May 20, 2015

**Subject: Century Tire Plaza – 195 Kennebec Street
Project ID# 2015-027
Review Comments Received May 7, 2015**

Drawing file: 5_21_15 submittal / Electrical Plan.pdf

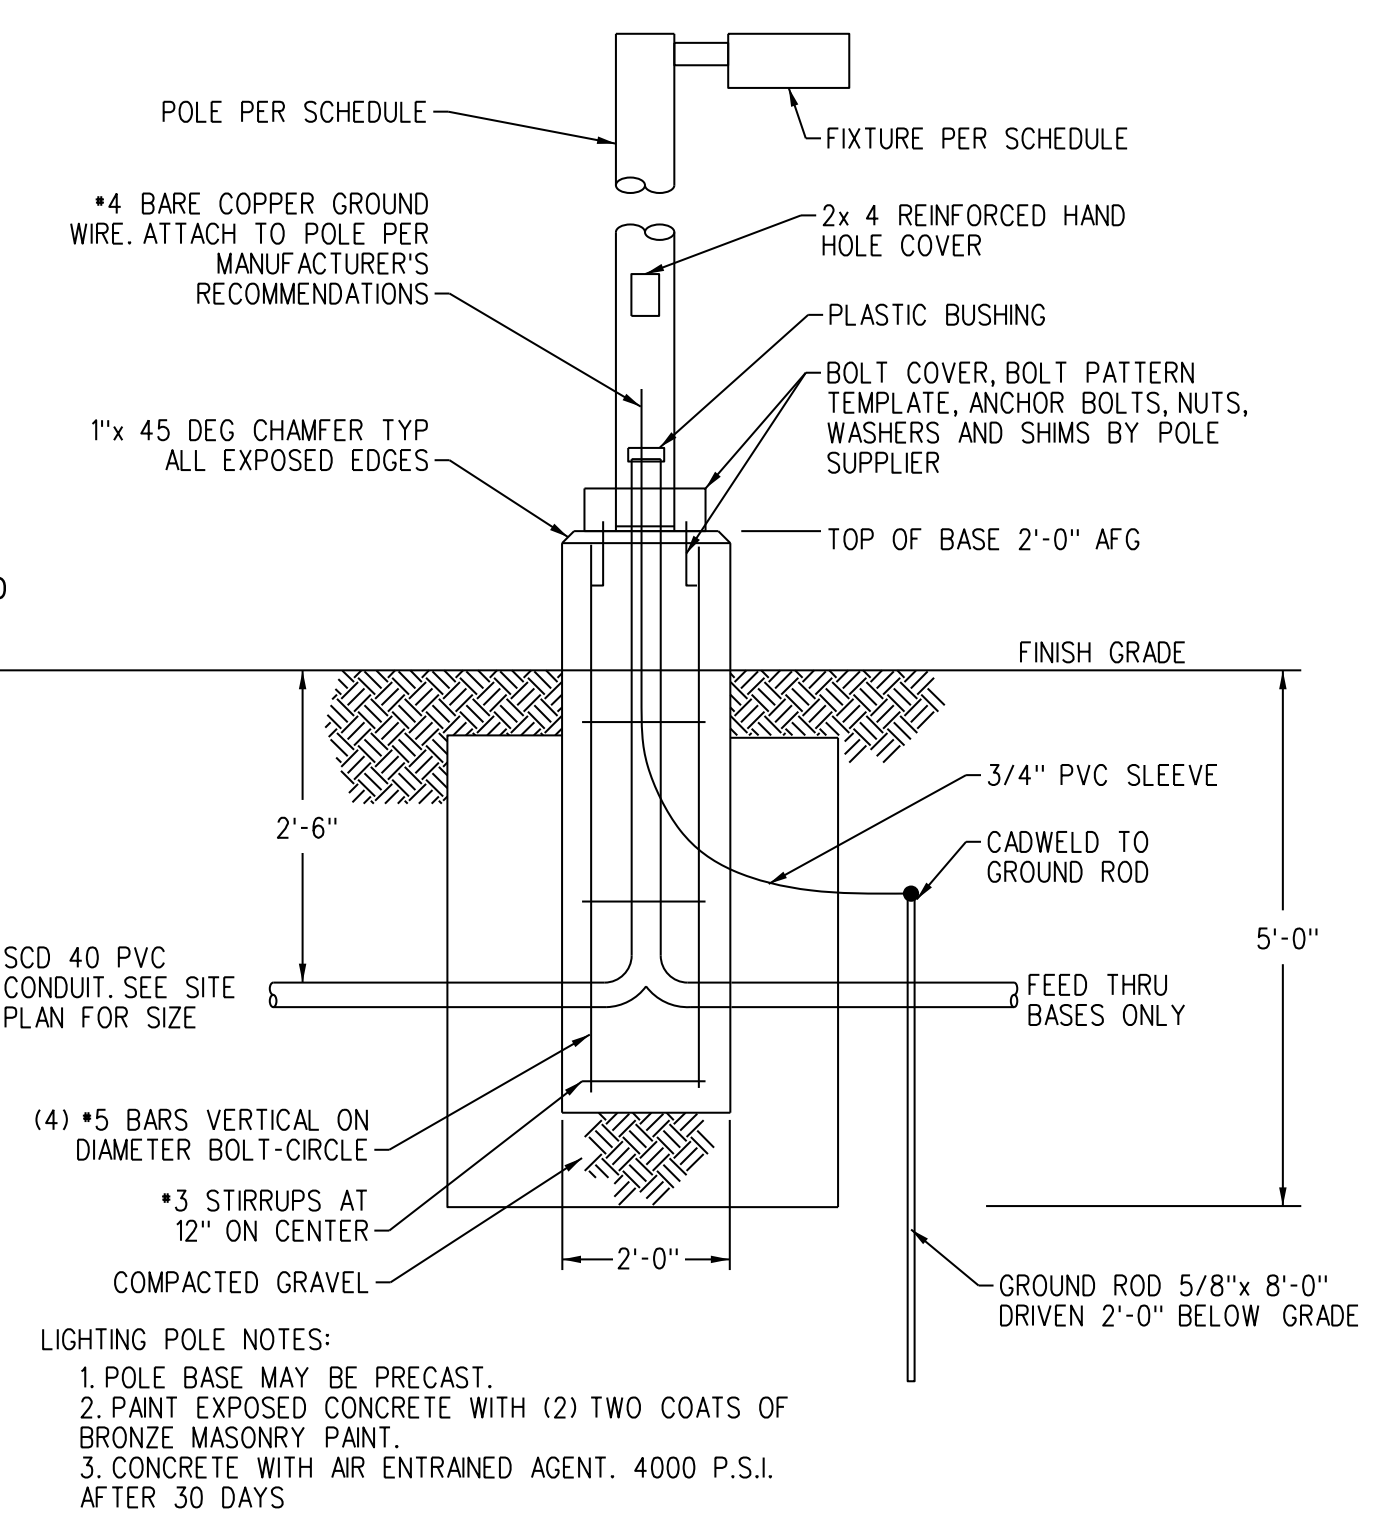
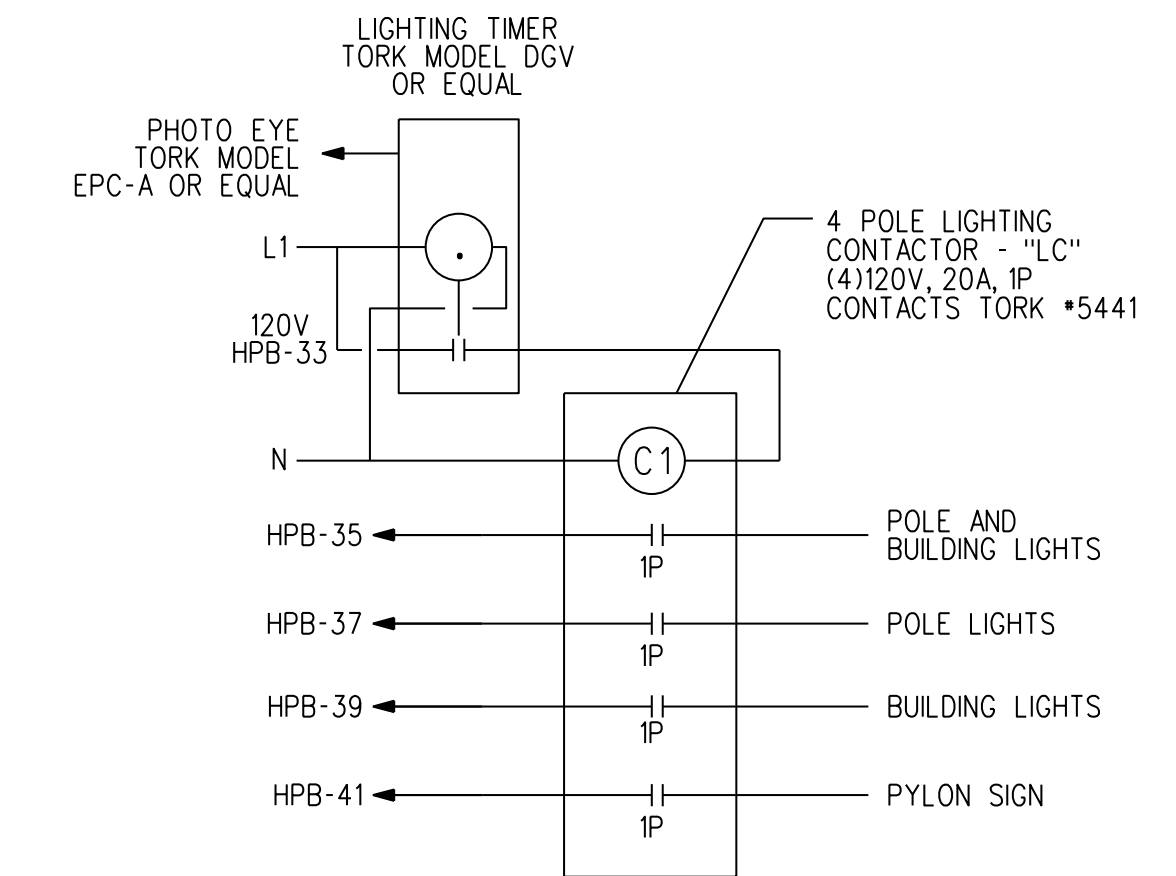
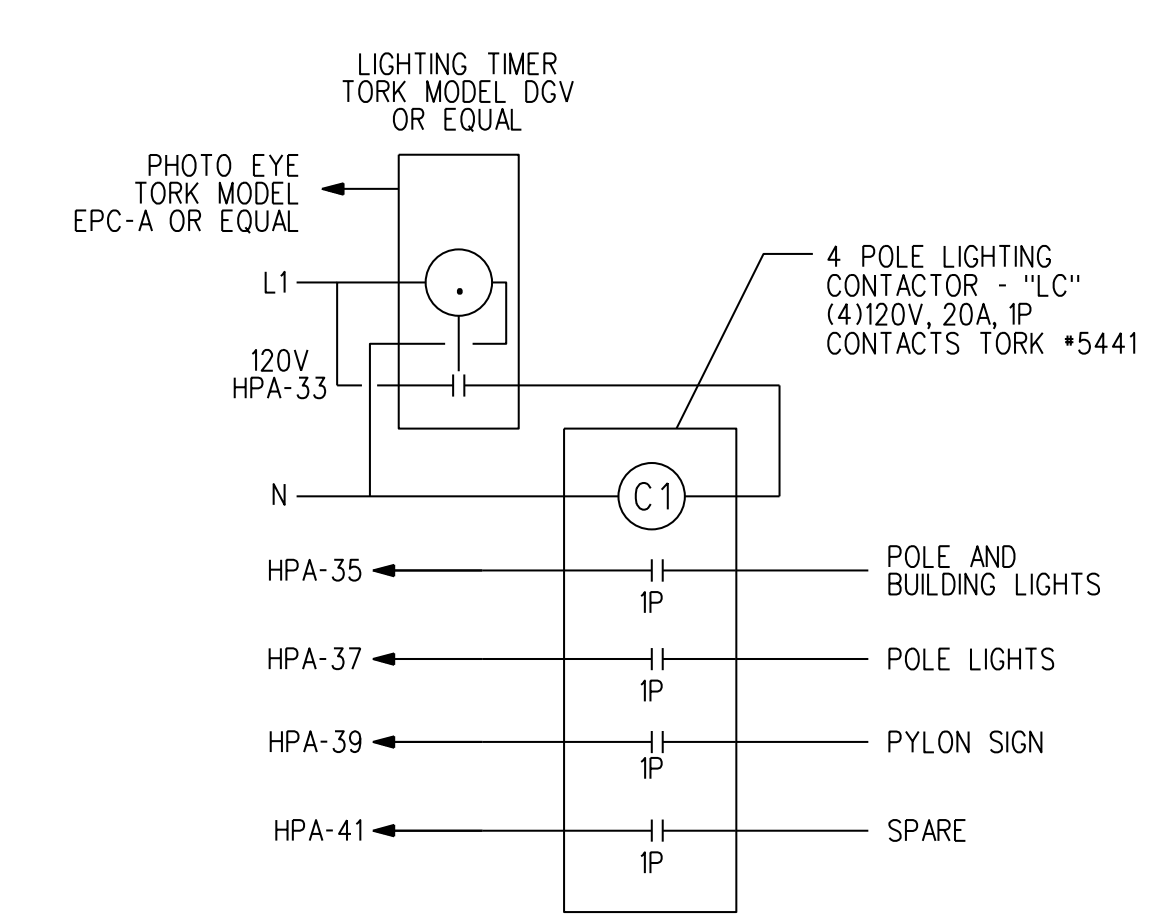
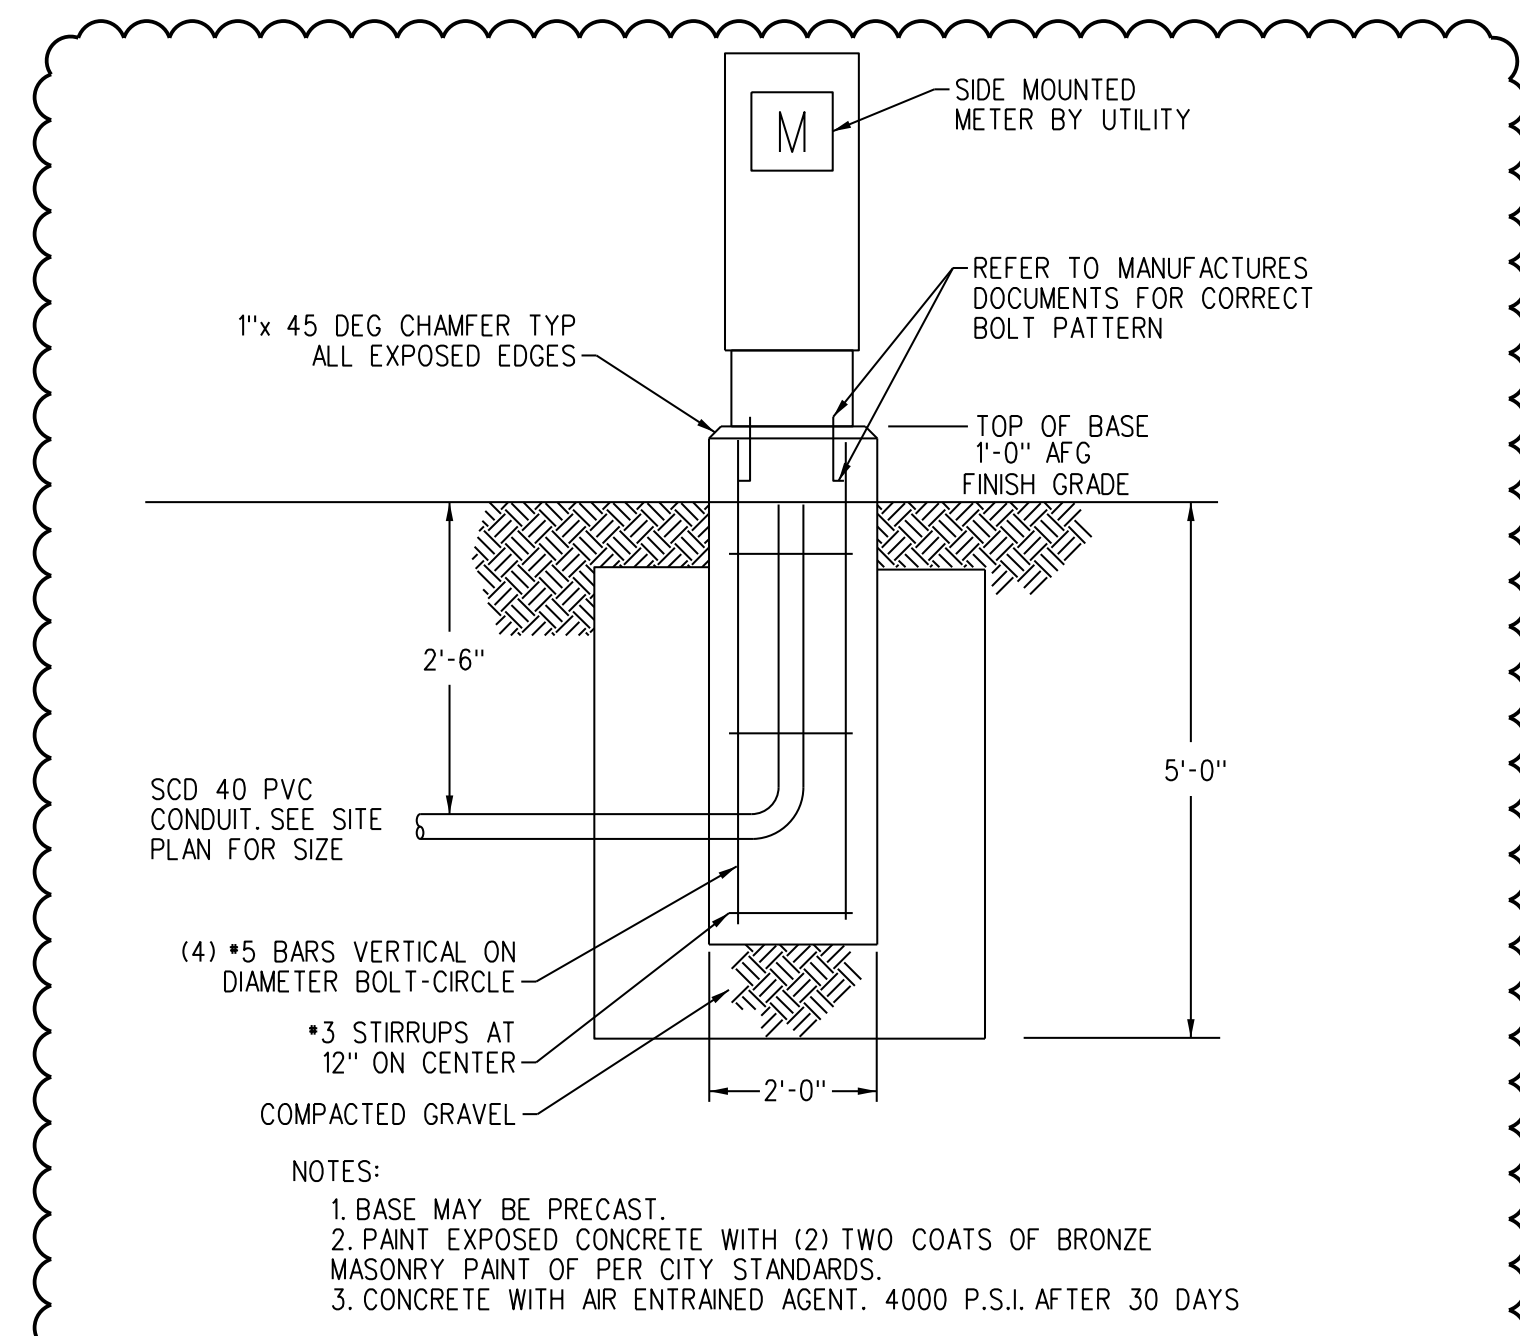
- 1. On Marginal Way, where does the proposed electrical conduit connect to the existing lighting circuit? Show the location and details of the connection. Show the location of the conduit to be installed.*

- 2. On Kennebec Street, show connection from the proposed meter to the utility power grid. Show the electrical panel design details.*
- 3. Specify the conduit size, type, and provide installation detail showing the depth of cover (minimum of 36"), conduit encasement, and marker tape.*

- 4. Specify and show the conduit location with respect to right of way or some other reference.*
- 5. Are light fixtures, poles, and pole foundations details provided?*

- 6. The applicant will be responsible for all connections, wiring and any other ancillary work required for a complete street project. Please delete reference that the City is responsible for such work.*

- 7. It is understood that all street lighting will have LED fixtures, all circuits metered for City billing and please not that a 120v outlet per pole is not required*

Please see revised electrical plan from Bennett Engineering that addresses these comments.
